# KIRKLEES METROPOLITAN COUNCIL

### UPDATE OF LIST OF PLANNING APPLICATIONS TO BE DECIDED BY STRATEGIC PLANNING COMMITTEE

**Planning Application 2016/92029**

**Erection of extension to existing Kingsgate Shopping Centre to form new Leisure Development including new cinema and restaurants, and demolition of existing buildings on the site including 20-22 Cross Church Street (partly within a Conservation Area)**

Content	PROPOSED CANOPY		
Client	WD KINGSGATE LTD		
Project	KINGSGATE LEISURE		
Date	MAY 2016	Drawing Scale	1:25@ A1, 1:50@A3
Paper size	A1	Drawn by	HB
Project Code	756F	Drawing No.	PL-16
		Revision	B

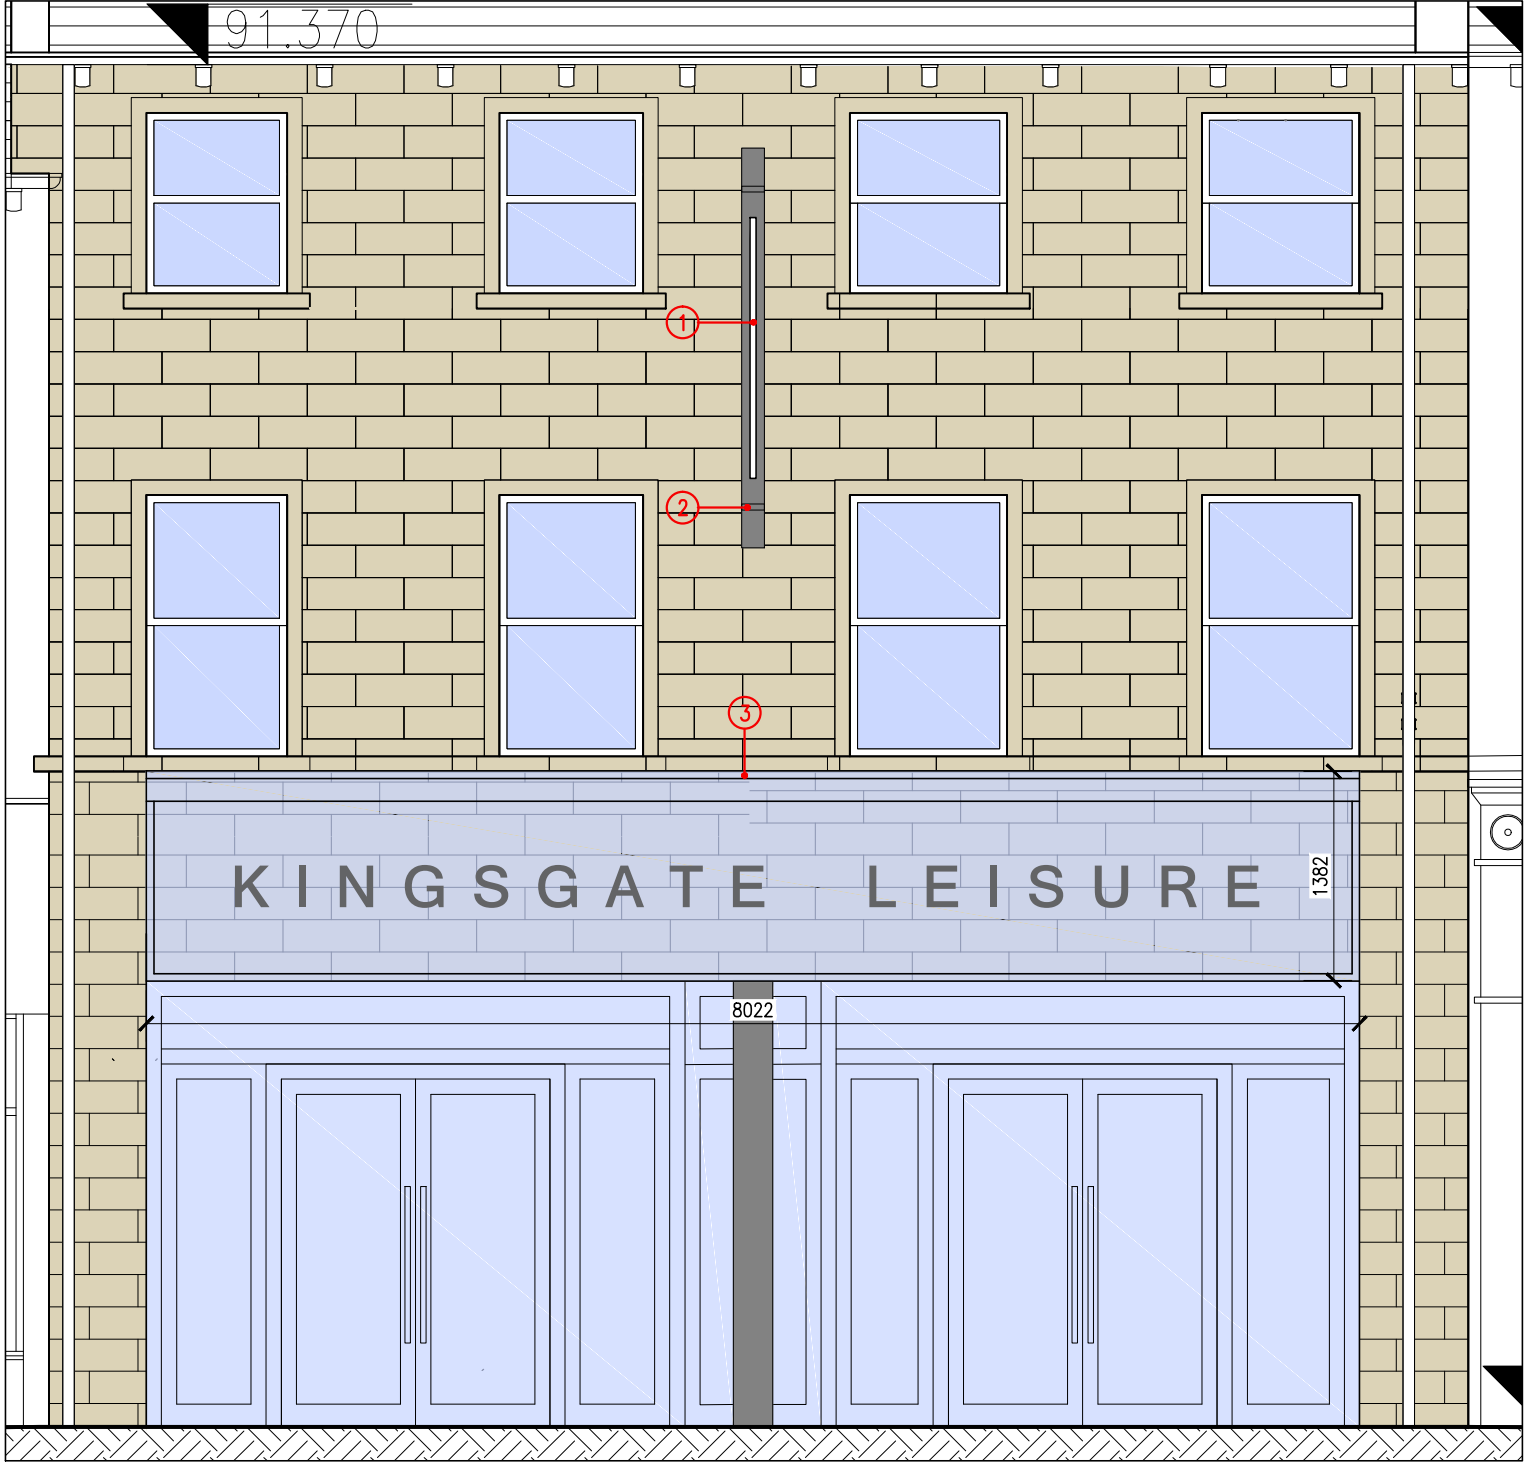
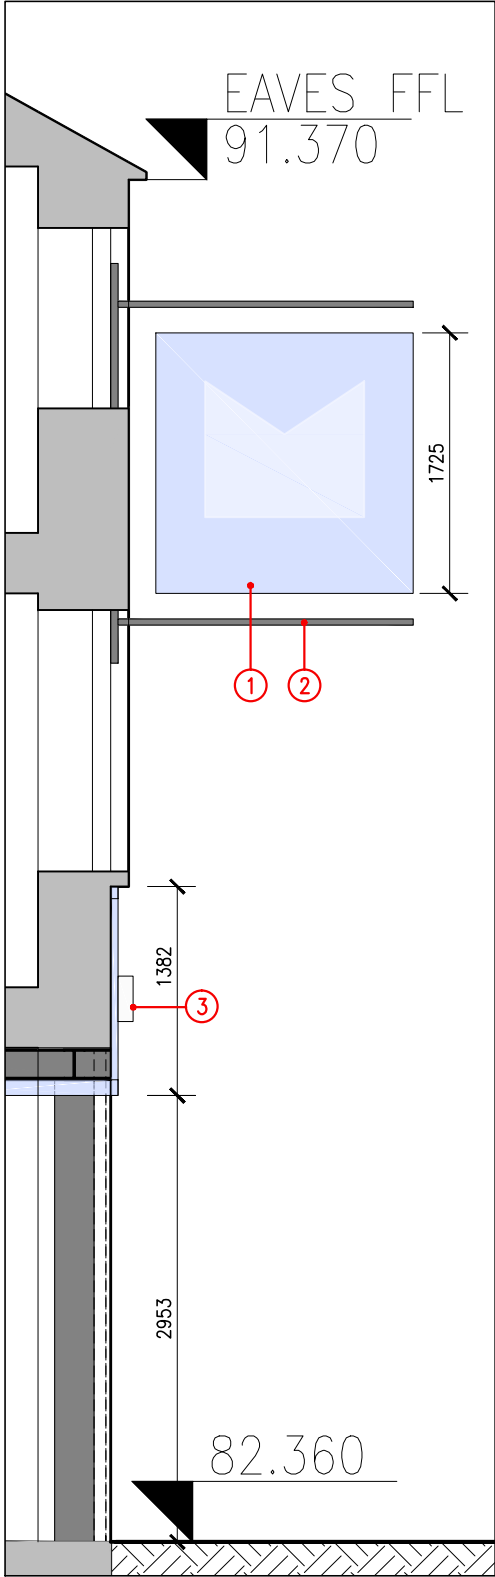
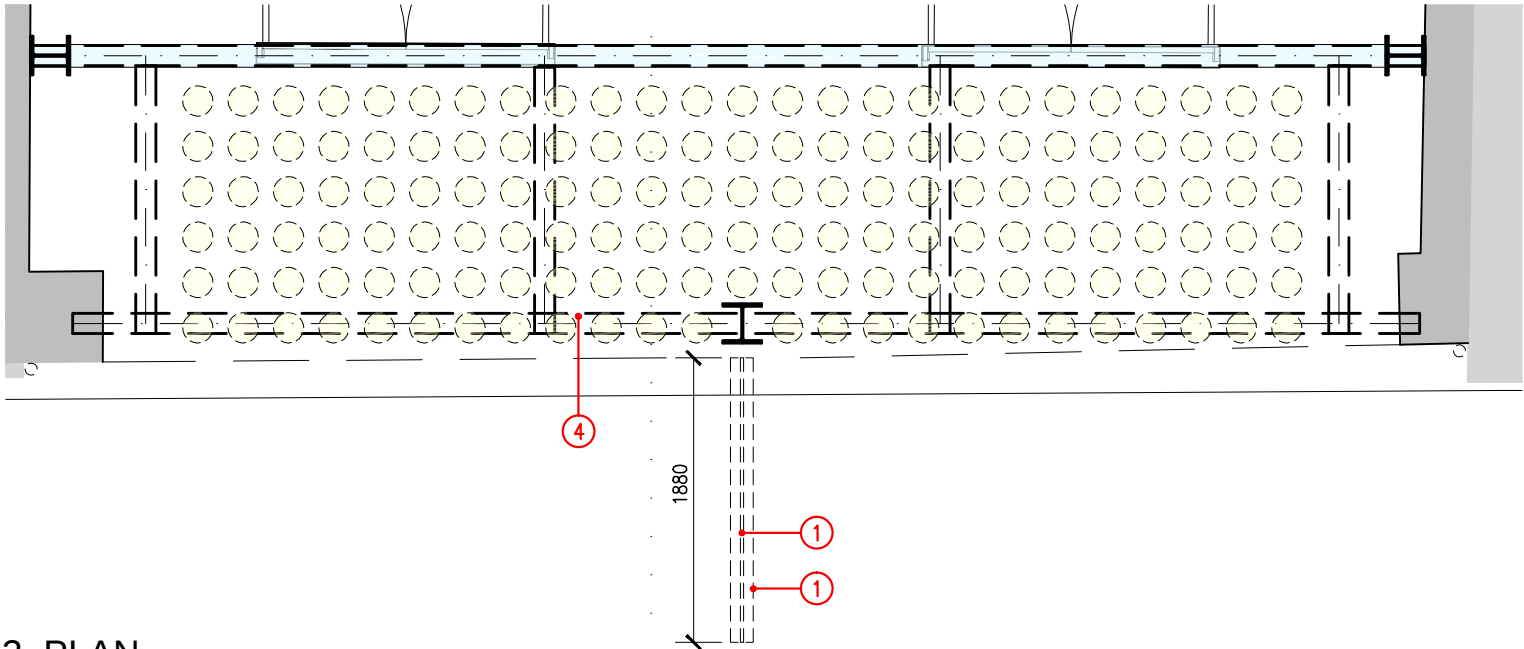
- Removal of the proposed canopy from 20-22 Cross Church Street. The alternative proposal for marking the entrance is to propose a hanging sign at first floor level, and a proposal for public art work on Cross Church Street.
- The introduction of a flat roof section to the proposed retail extension where the proposal abuts the former Palace Theatre.

Despite the evident improvements, however, we maintain our objection to the application on two principal grounds: firstly, the proposed canopy and totem way markers, which we have consistently recommended are omitted from the scheme, remain a part of the proposals (now omitted from the scheme). For the reasons outlined in my previous letter (a copy of which is attached) we object to this damaging aspect of the proposals.

Following the removal of the canopy from the frontage of 20-22 Cross Church Street, Historic England have removed their objection and no longer wish to exercise their right to call in the application to the Secretary of State. They recommend that if the development cannot be amended to avoid all harm, then this harm should be weighed against the public benefits of the scheme, including securing the optimum viable use of the designated heritage assets.

As noted above, the plans have been further revised and the canopy and way markers have now been removed. In respect to the proposed alterations to 20-22 Cross Church Street, revisions have been secured during the course of the application to restrict the proposed entrance opening to the ground floor, where alterations to the shop fronts have already occurred. The Victorian Society has not indicated that they would call in the application, and the harm has to be weighed against public benefit.
